Please ask for: Ms Iqraa Malik
Email: iqraa.malik@terraquest.co.uk
Telephone: 01212341390
Our Ref: A/62/21/HH
Your Ref:
Date: 8th April 2021

Application for Planning Permission for Works or Extension to a Dwelling

Development: Erection of a small one storey extension to the rear of the property.
Location: 8 Lavender Way Angmering BN16 4QD

Plan Reference Number: TQRQM21091161253143

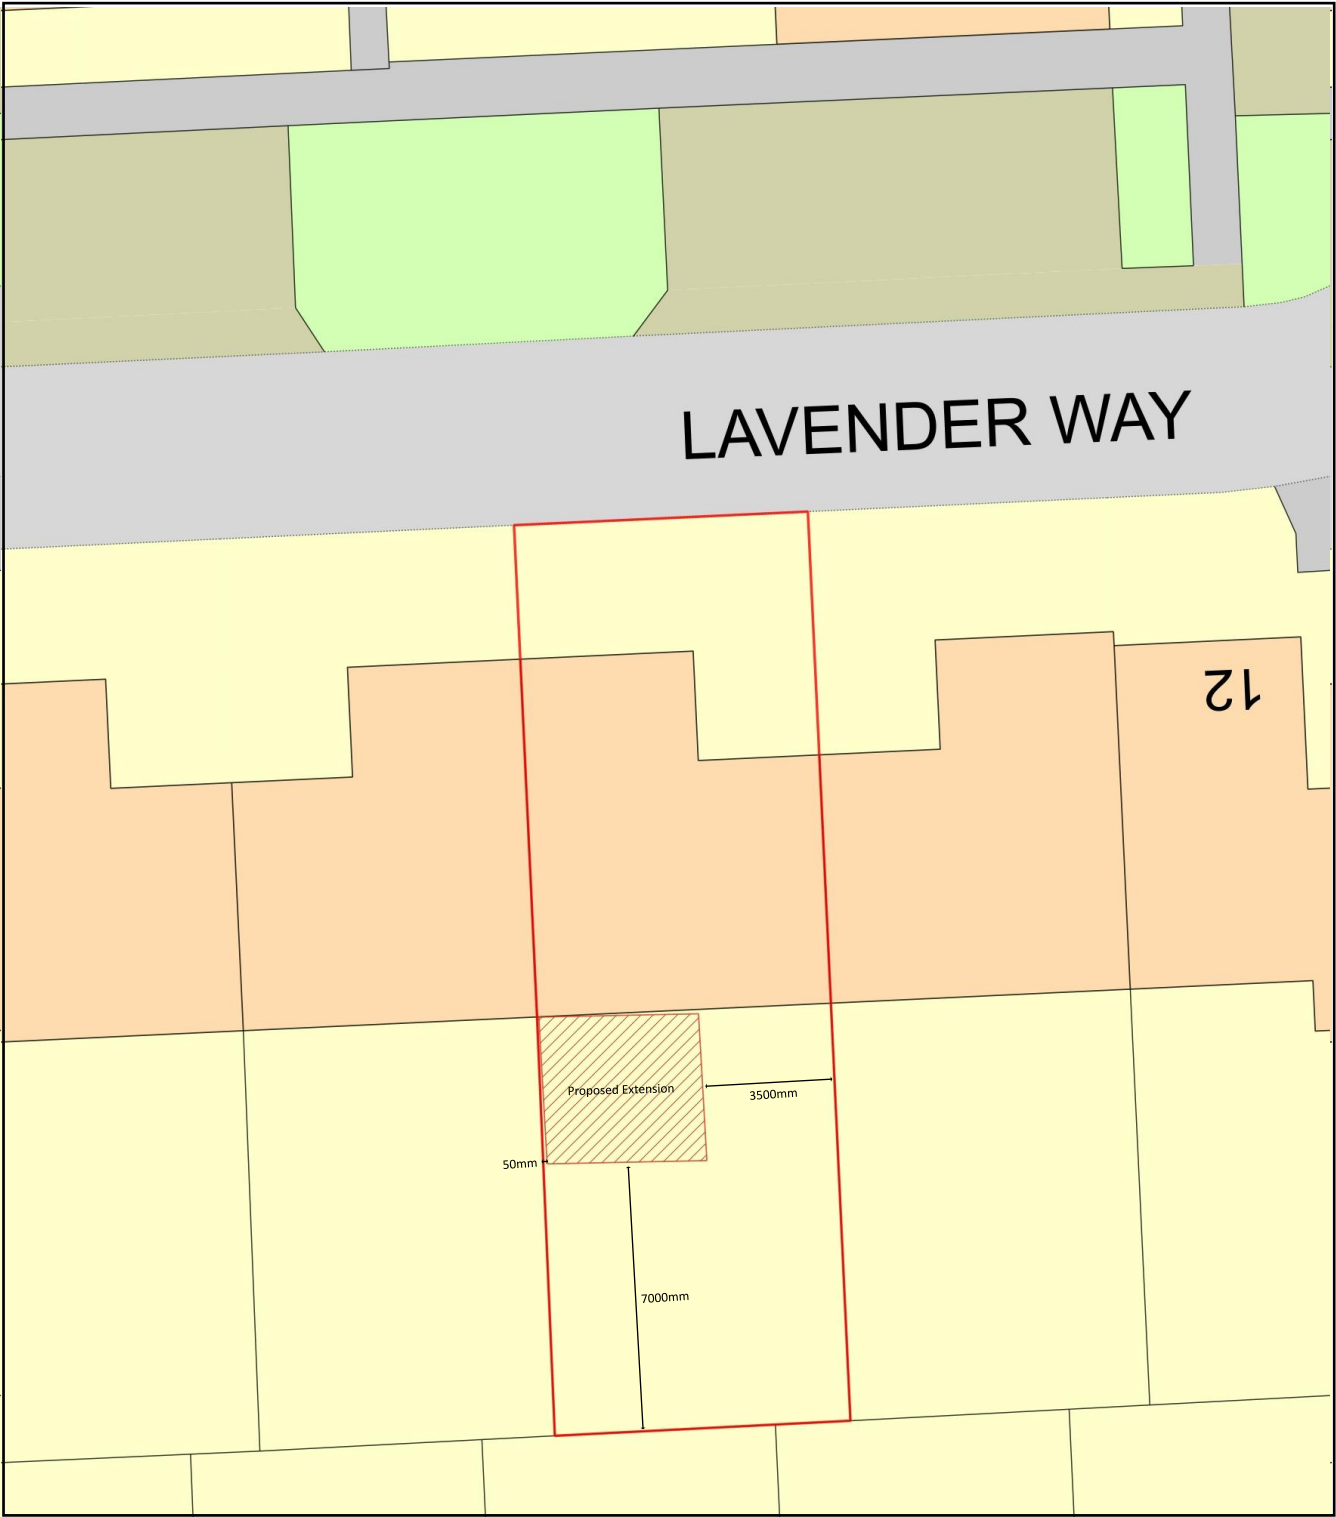
Dimensions: You are required to include dimensions on the block plan from the proposed extensions to all site boundaries.
